MIRVAC

AUSTRALIAN TECHNOLOGY PARK
- BUILDING 1
- BUILDING 2
- COMMUNITY BUILDING
- PUBLIC DOMAIN

ACCESS REVIEW

10th December 2015

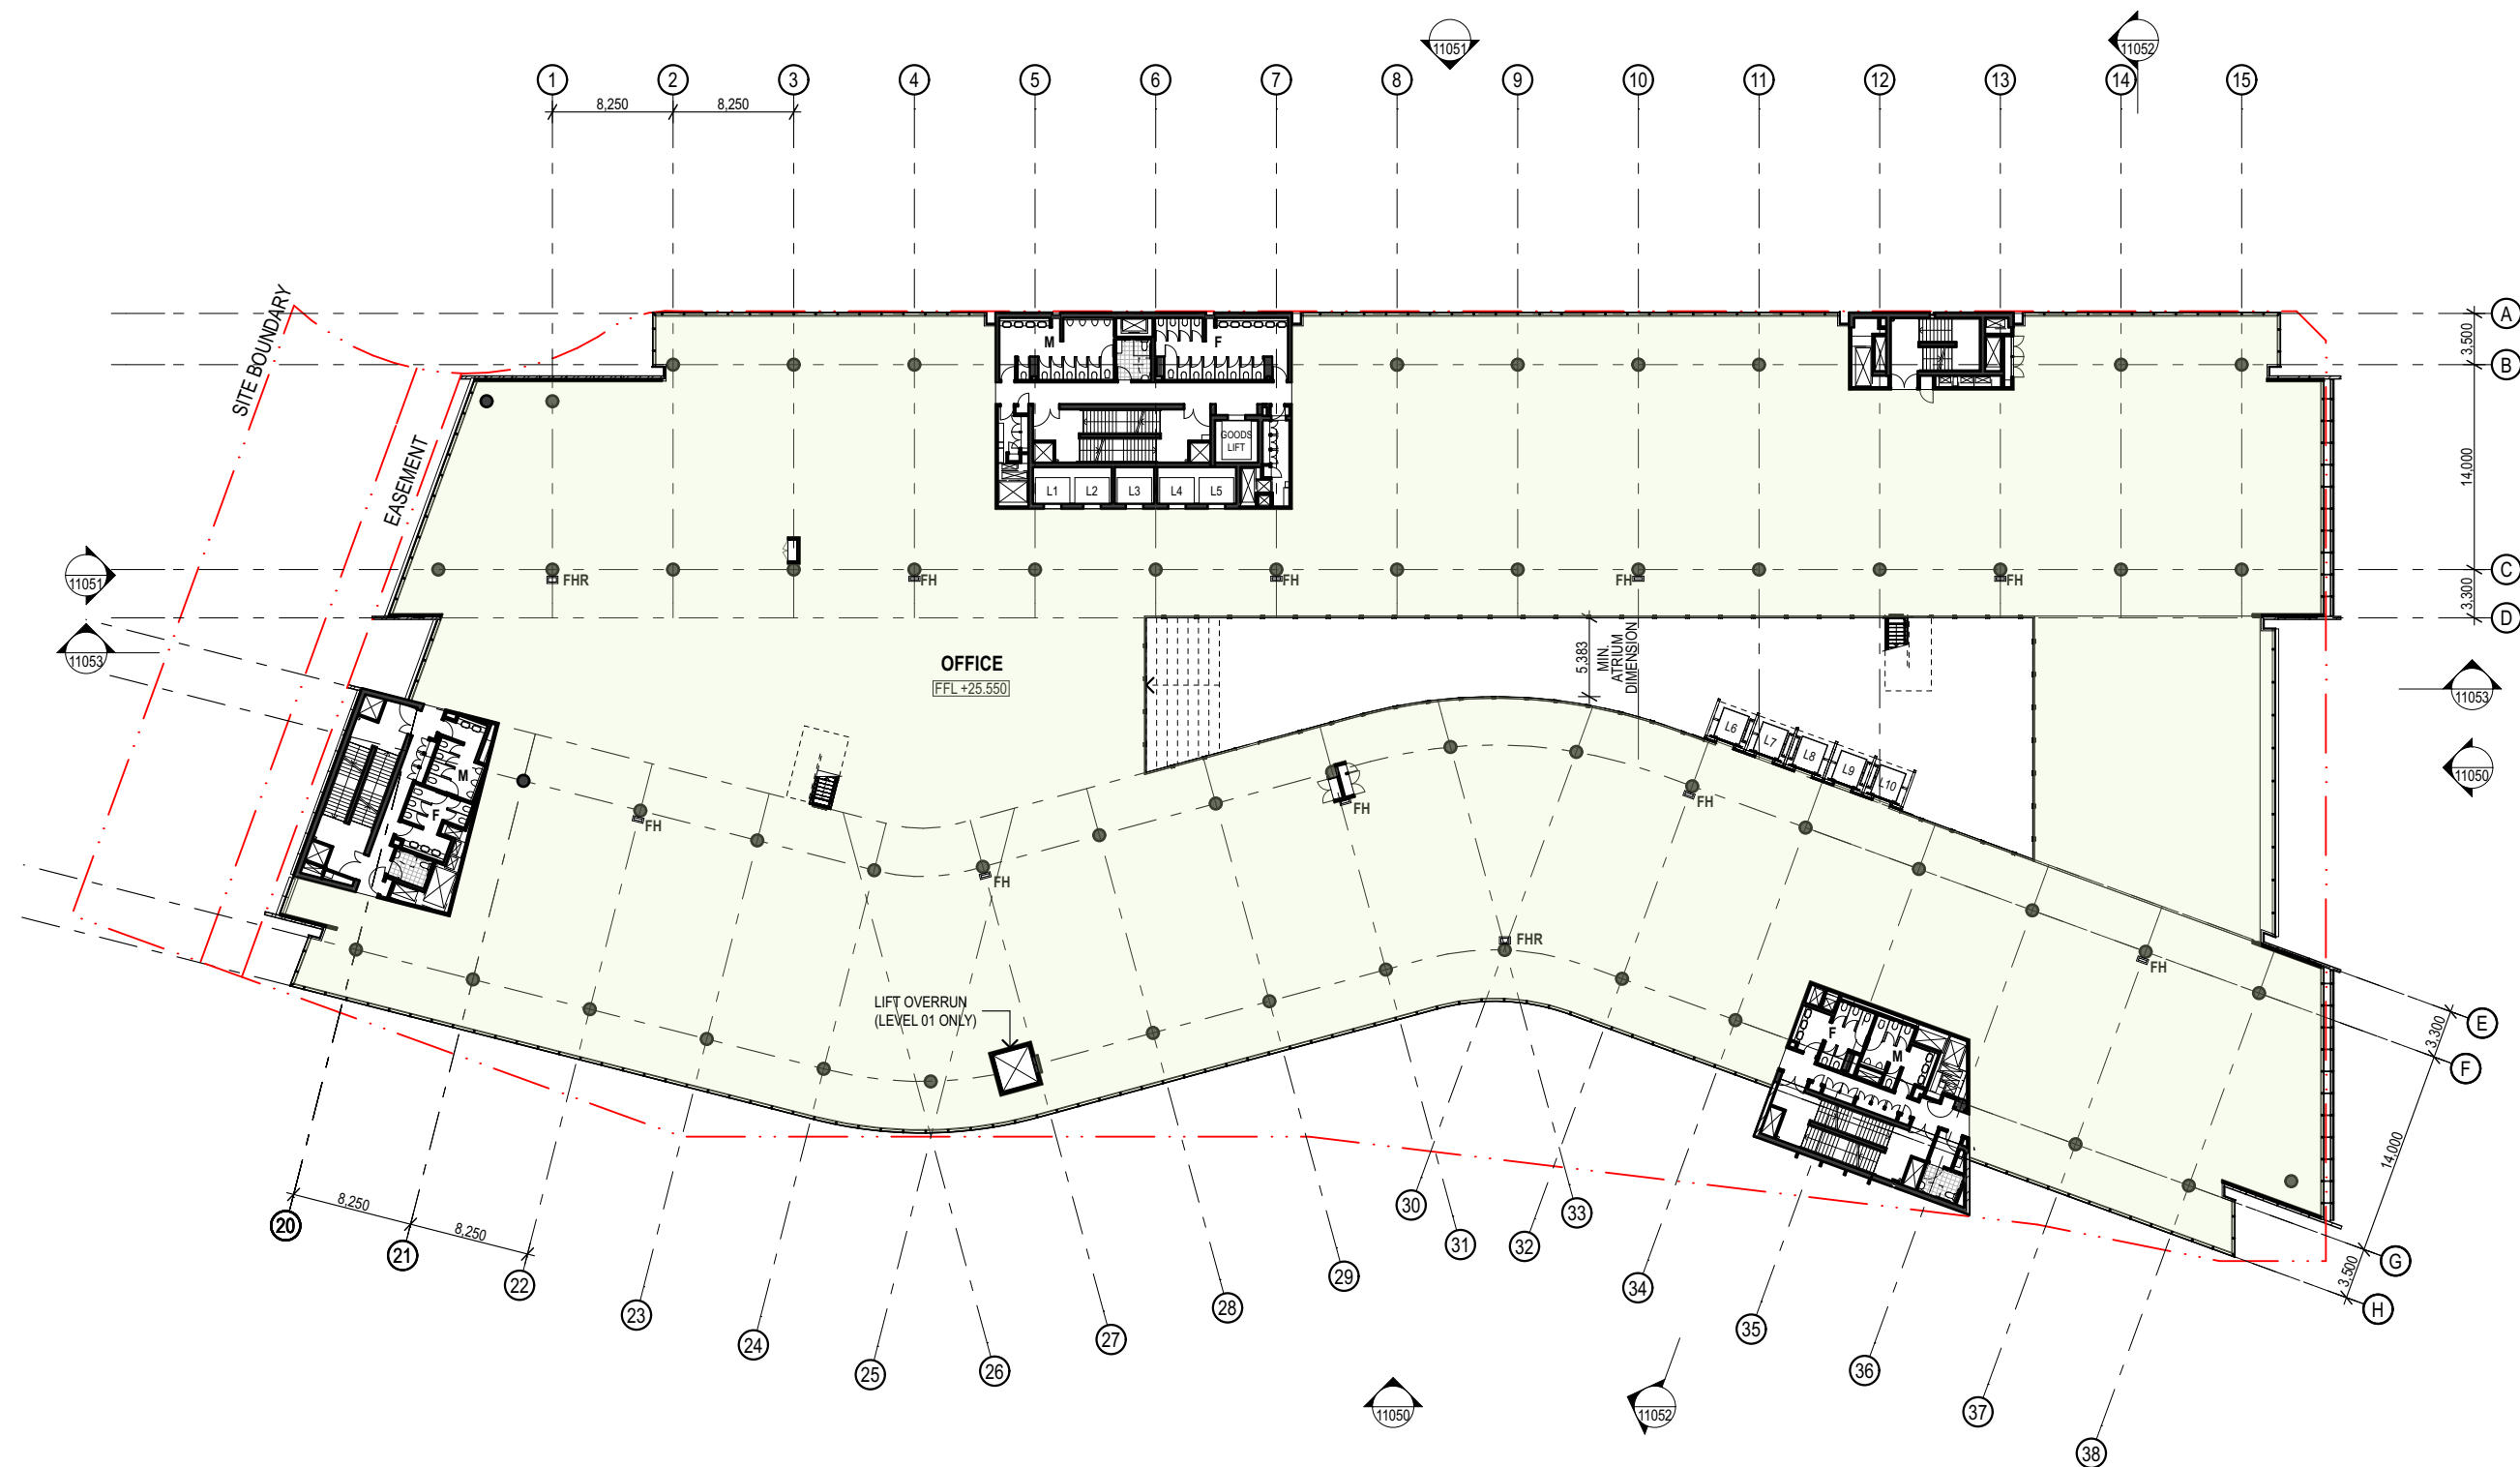
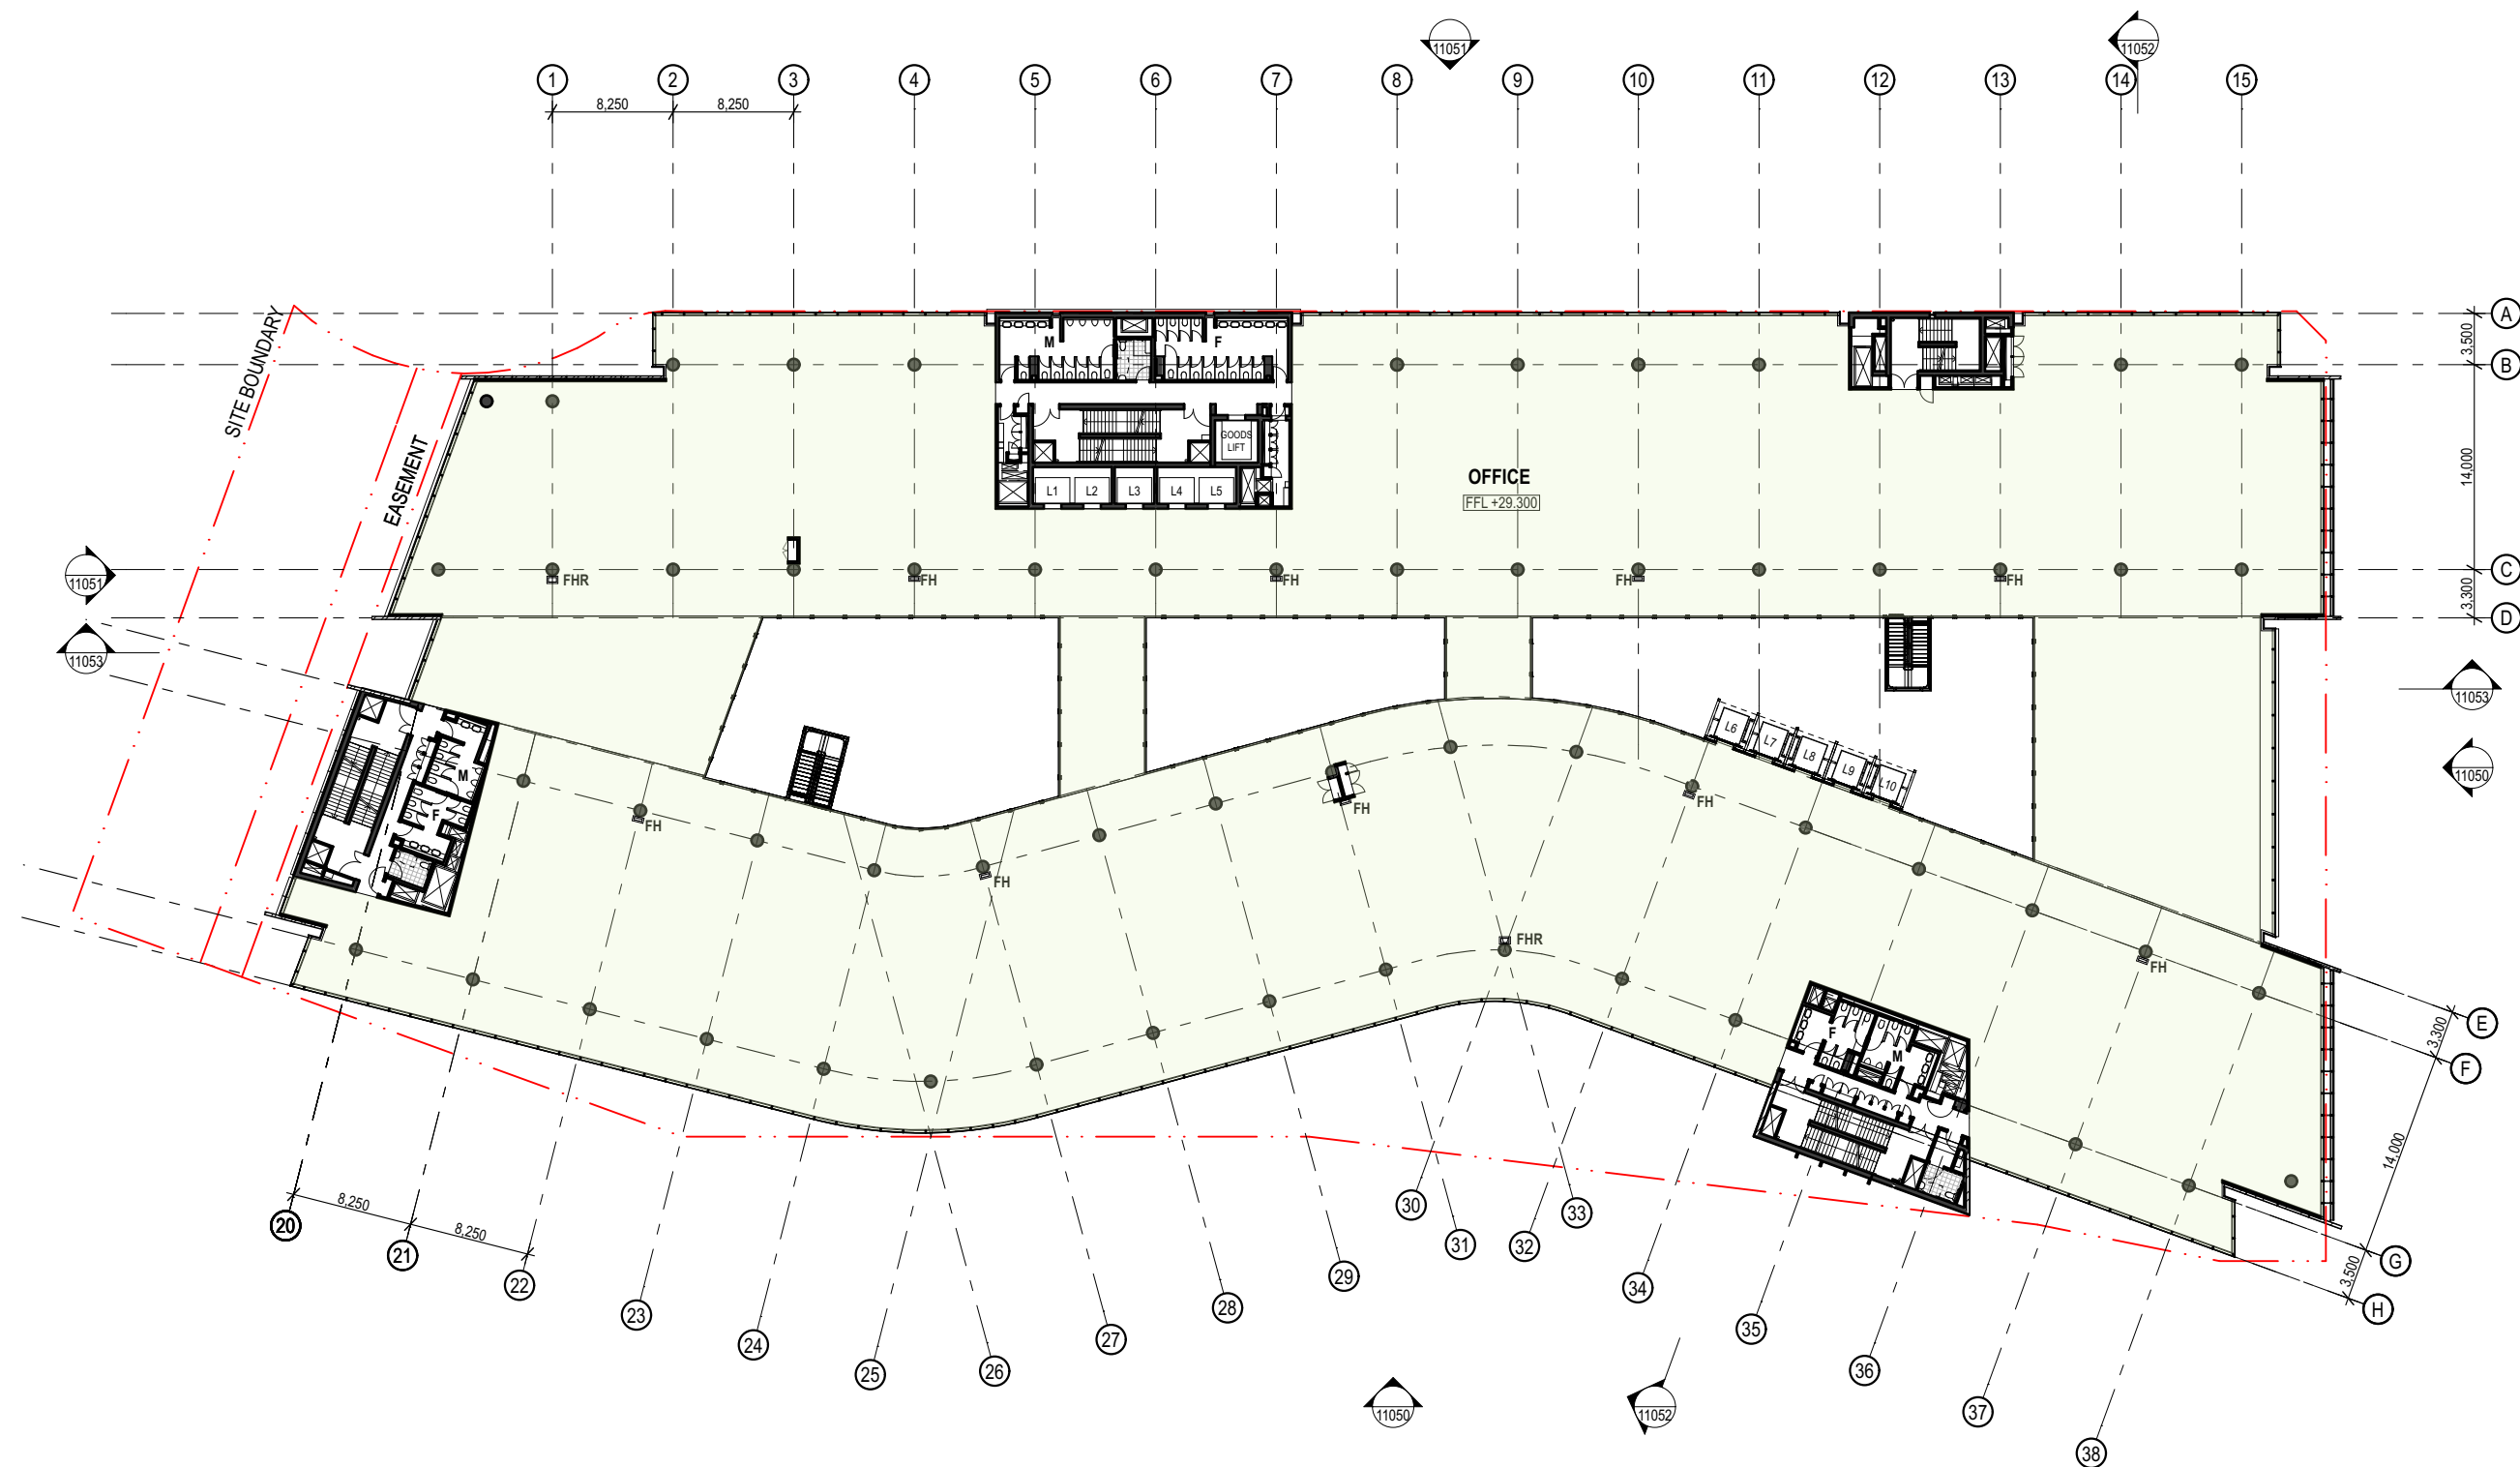
However, the accessible path of travel from the accessible car bays located on the floor ground floor level to the entry point of the End of Trip Facilities will need to be provided with turning circles, 1540mm in width for a minimum length of 2070mm, for compliance under AS1428.1:2009. This is due to the current corridor having a length greater than 20m and a width of only 1500mm.

However, the basin located within the right hand transfer accessible toilet currently encroaches within the circulation space of the shower. This is due to the structural column located to the corner of the room.

Also, drawings indicate there to be a total of 17 right hand transfer pans and only 8 left hand transfer pans. As per the DDA Premises Standards, an even amount of left and right handed pans is required to fulfil compliance.

Car parking has been provided to the lower ground floor level, mezzanine level and upper ground floor level of the building, with a total of 217 car spaces. A total of 5 accessible parking bays have been provided to the lower ground floor level. The number of accessible parking bays satisfies the requirements of the DDA Premises Standards table D3.5.

- (i) Ensure flooring systems used comply with BCA and HB198/AS4586.
- (ii) Turning circle of no less than 1540mm wide x 2070mm length to be provided to the accessible path of travel leading from the accessible car bays to the entry point of the End of Trip Facilities on the lower ground floor level.

- (i) Ensure a clear circulation space about the shower recess to the ground floor accessible toilet of 1600mm x 2350mm, compliant with AS1428.1:2009.
- (ii) The public accessible toilets throughout shall have suitable pan locations that allow a mixture of left and right transfer pans, compliant with AS1428.1:2009 and the DDA Premises Standards.
- (iii) Ensure all bathroom fixtures comply with AS1428.1:2009.

- (i) Ensure the accessible car bay has a vertical clearance of 2.2m whilst travelling to the accessible car bay and 2.5m within the accessible car bay, compliant with AS2890.6.
- (ii) Ensure there is a safe and accessible path of travel to the lifts from the car bays. Consideration shall be given as to relocate the accessible parking bay closer to the lift lobby.
